DEVELOPMENT REVIEW BOARD
SUPPLEMENTAL SUBMITTAL

PROJECT NO. PR-2019-002184
Application No. SI-2019-00379

**RE: Guardian Storage- Juan Tabo
4909 Juan Tabo NE
Conceptual Grading and Drainage Plan Stamp Date: 12/20/19
Hydrology File: F21D081**

SHEET TITLE: CONCEPTUAL DRAINAGE PLAN

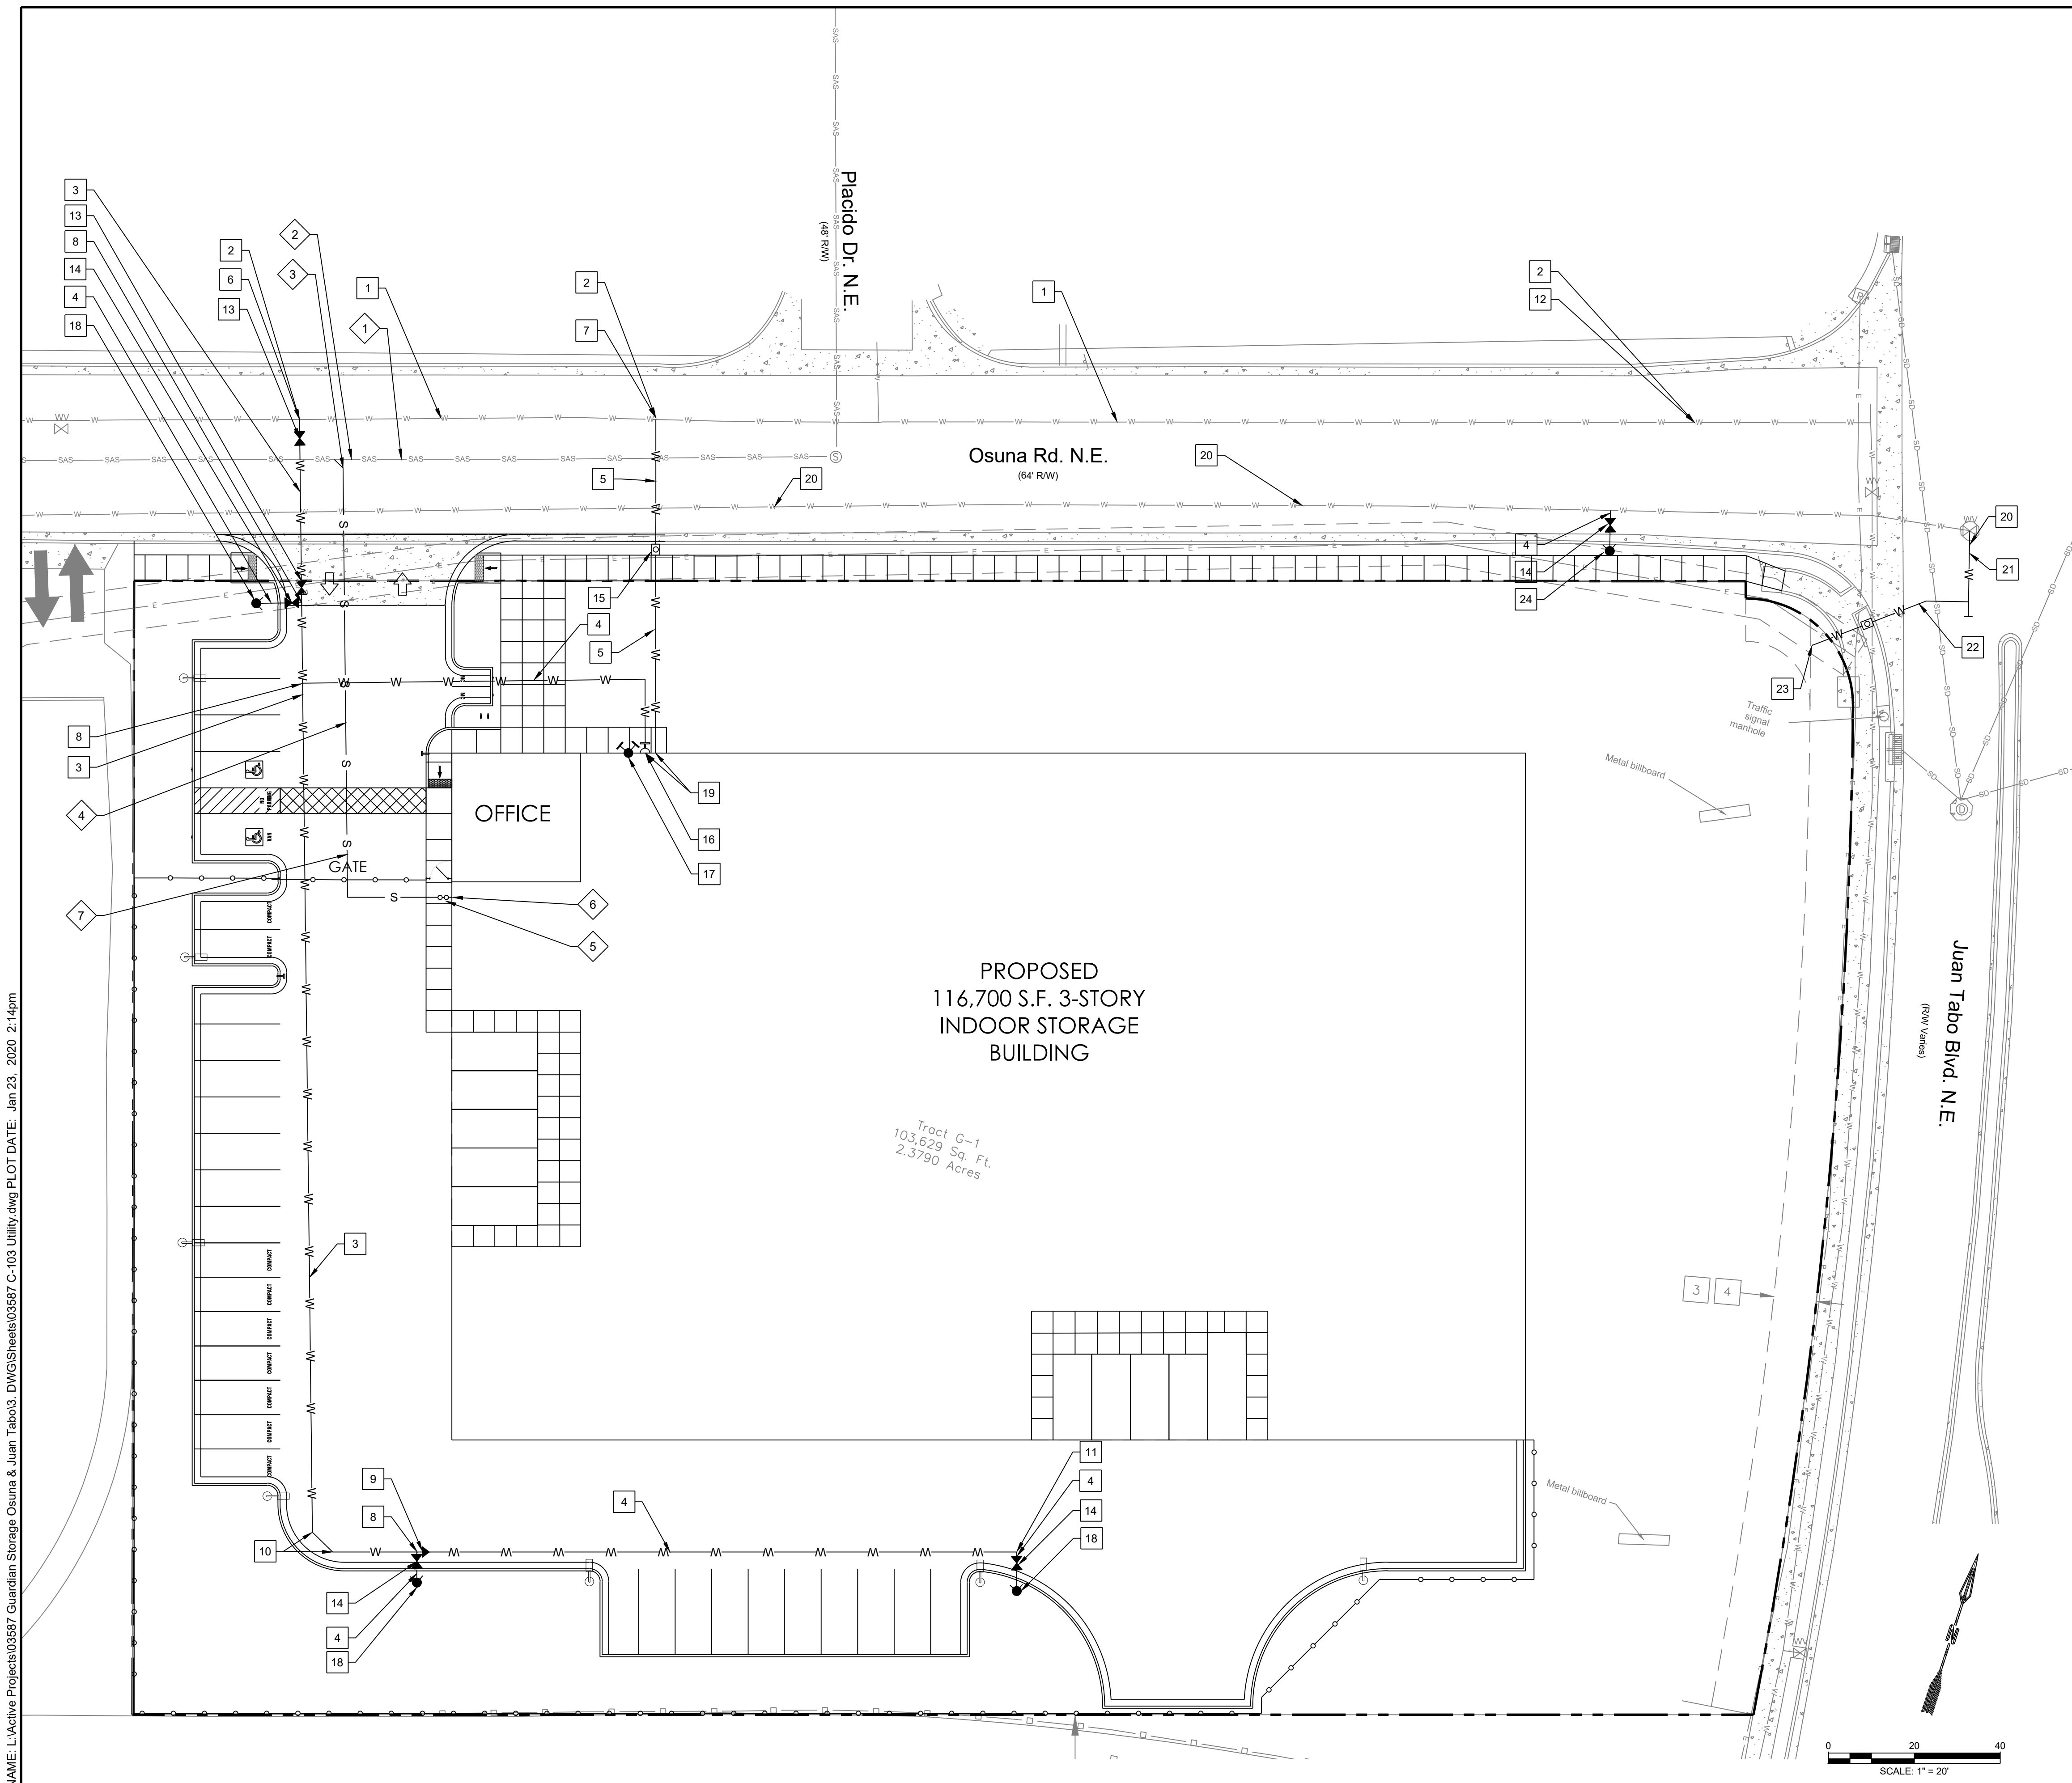
1. Remove all "Conceptual" markings.
2. As a reminder, if the project total area of disturbance (including the staging area and any work within the adjacent Right-of-Way) is 1 acre or more, then an Erosion and Sediment Control (ESC) Plan and Owner's certified Notice of Intent (NOI) is required to be submitted to the Stormwater Quality Engineer (Doug Hughes, PE, jhughes@cabq.gov, 924-3420) 14 days prior to any earth disturbance.
3. Provide hydraulic calculations for the proposed storm drain outfall, calculated along the Energy Grade Line; include both the HGL and EGLs. The 10-yr water surface in Bear Canyon Arroyo may be used as the control surface for the storm drain HGL calculations.
4. Additional comments may be provided at Building Permit, based on the outcome of the above remarks and level of detail shown on plans.
